RE: Miss Portland Diner revised plan, 138 Marginal Way, CBI: 442-A-6; #2007-0052

On December 19, 2007 the Portland Planning Authority reviewed and approved certain revisions to the approved site plan review for the proposed Miss Portland Diner and building addition in the vicinity of 138 Marginal Way subject to the following conditions of approval.

TO: Rick Knowland
FROM: Dan Goyette, PE – Development Review Engineer, Woodard & Curran
DATE: May 11, 2007
RE: Miss Portland Diner Minor Site Plan Review

N/F
STATE OF
MAINE
(INTERSTATE 295)

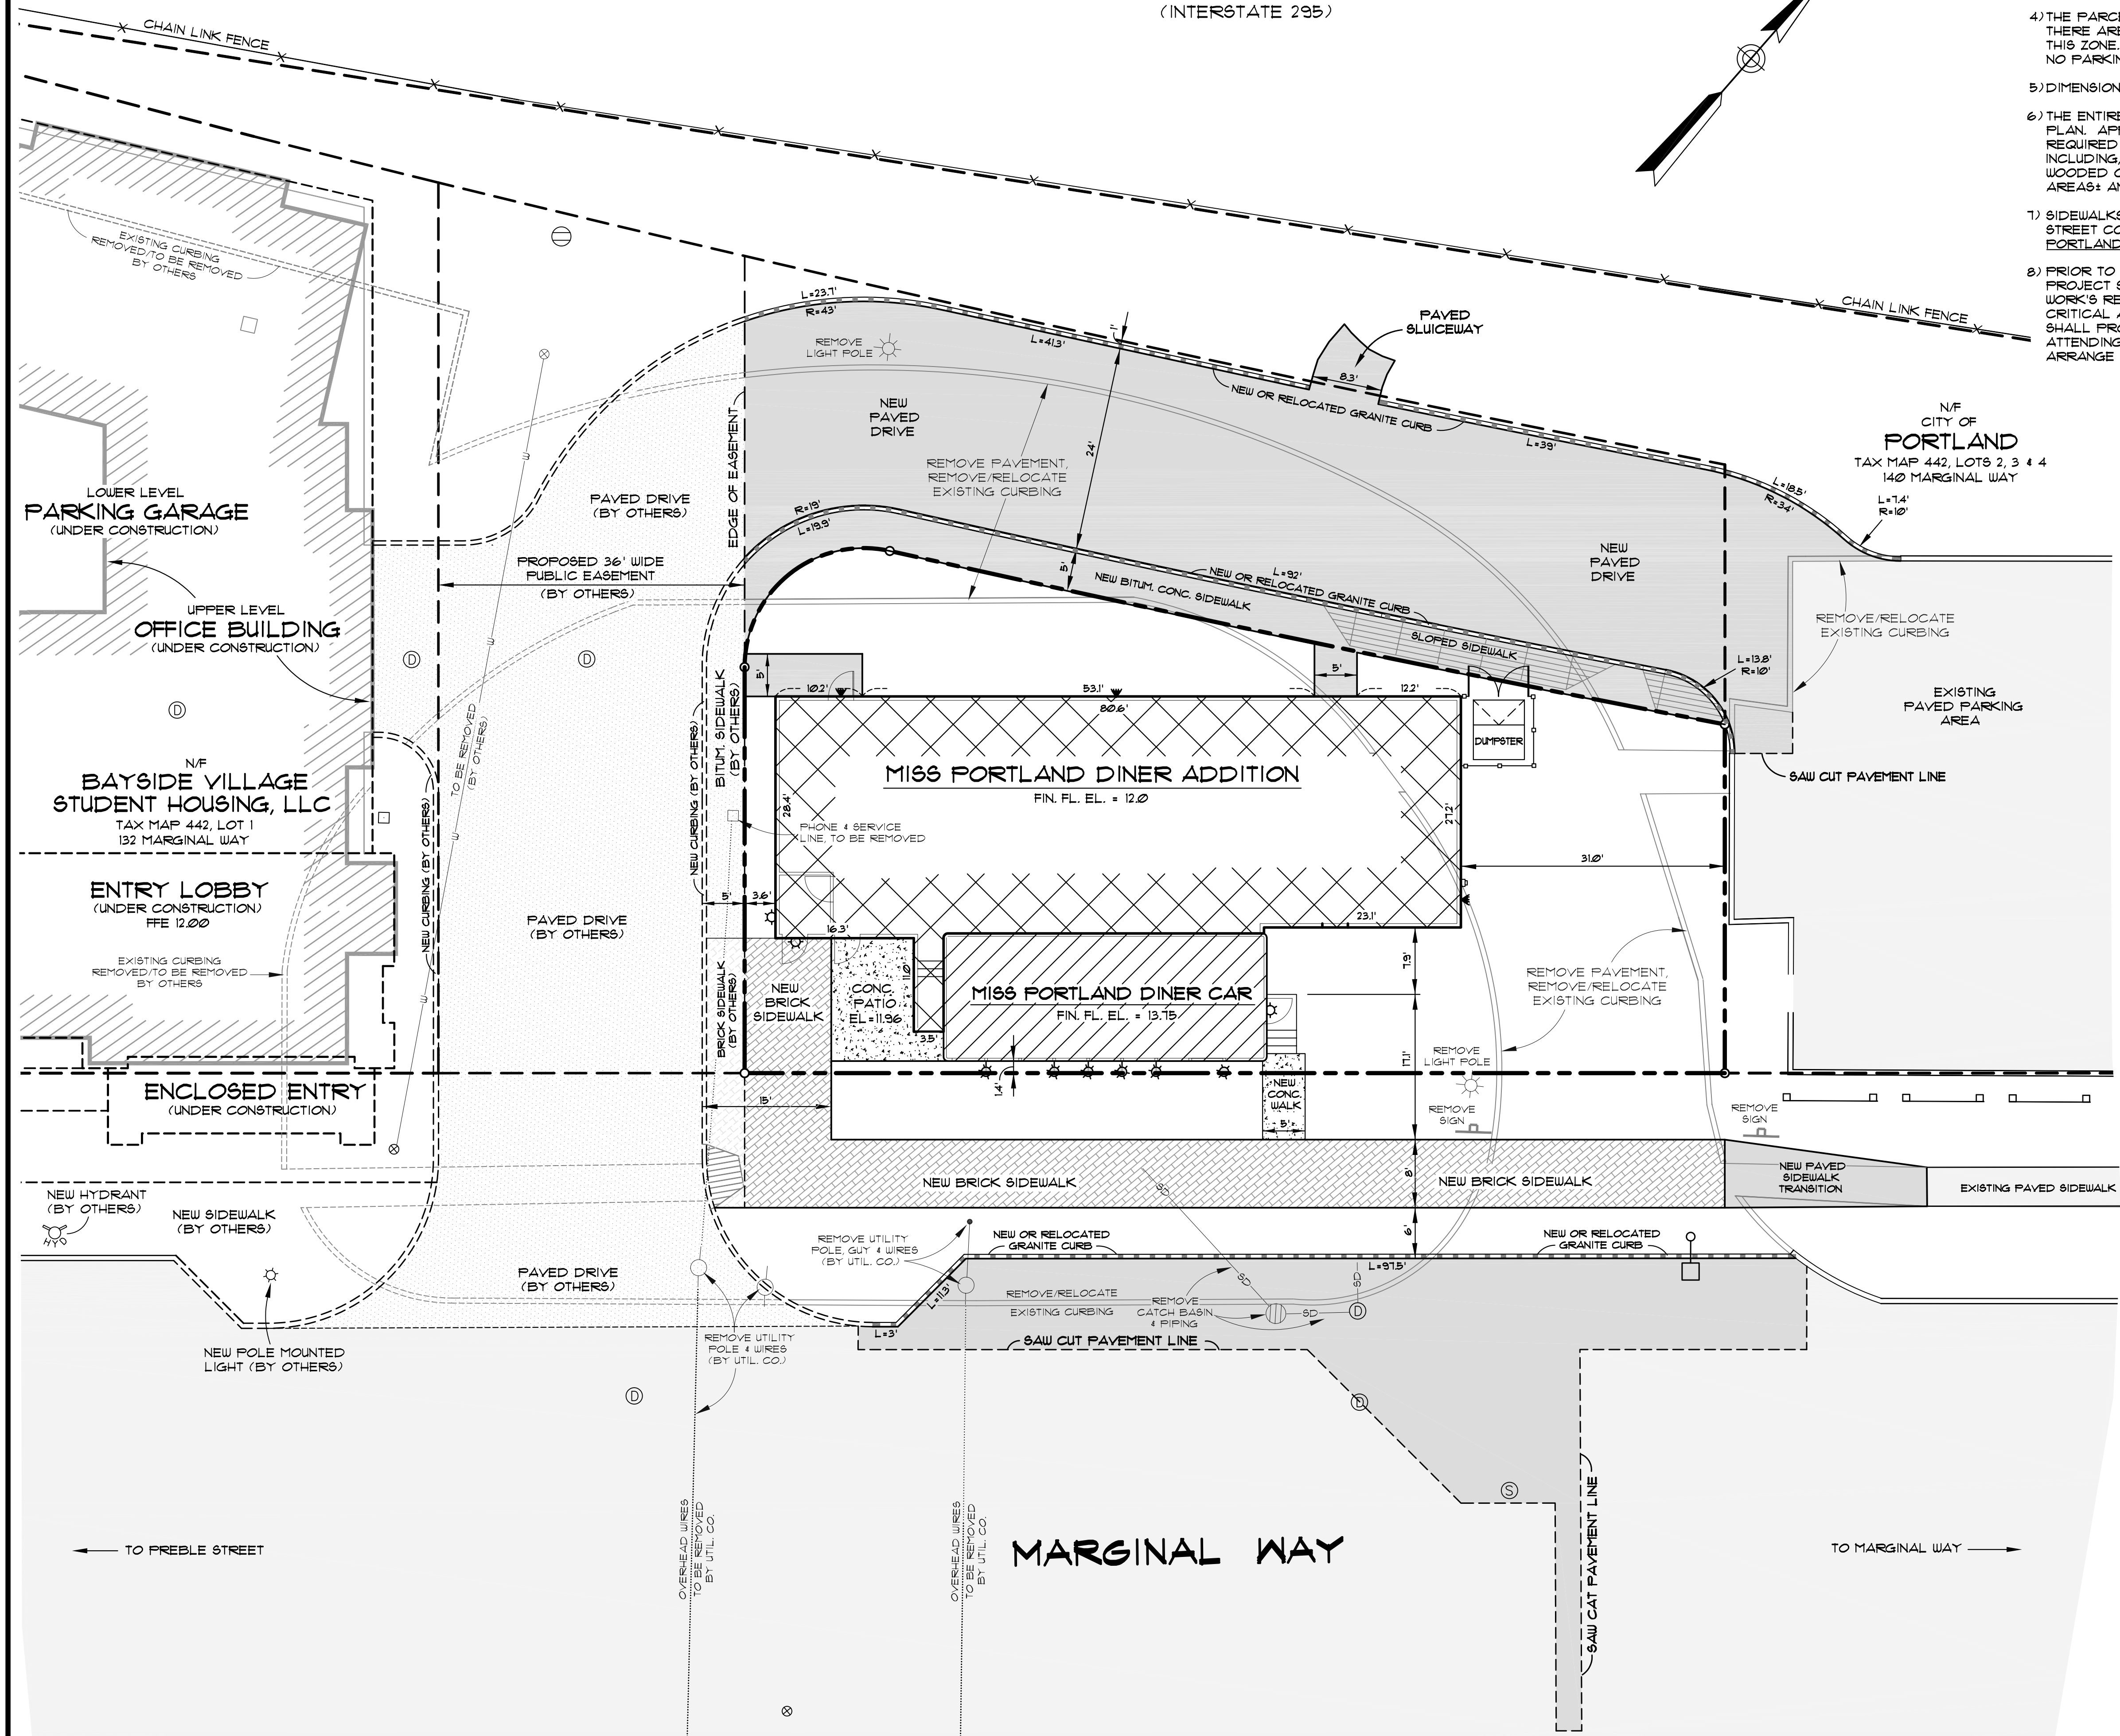
9. The width of the driveway behind the diner shall be 24 feet not 23 feet as shown on the plan.
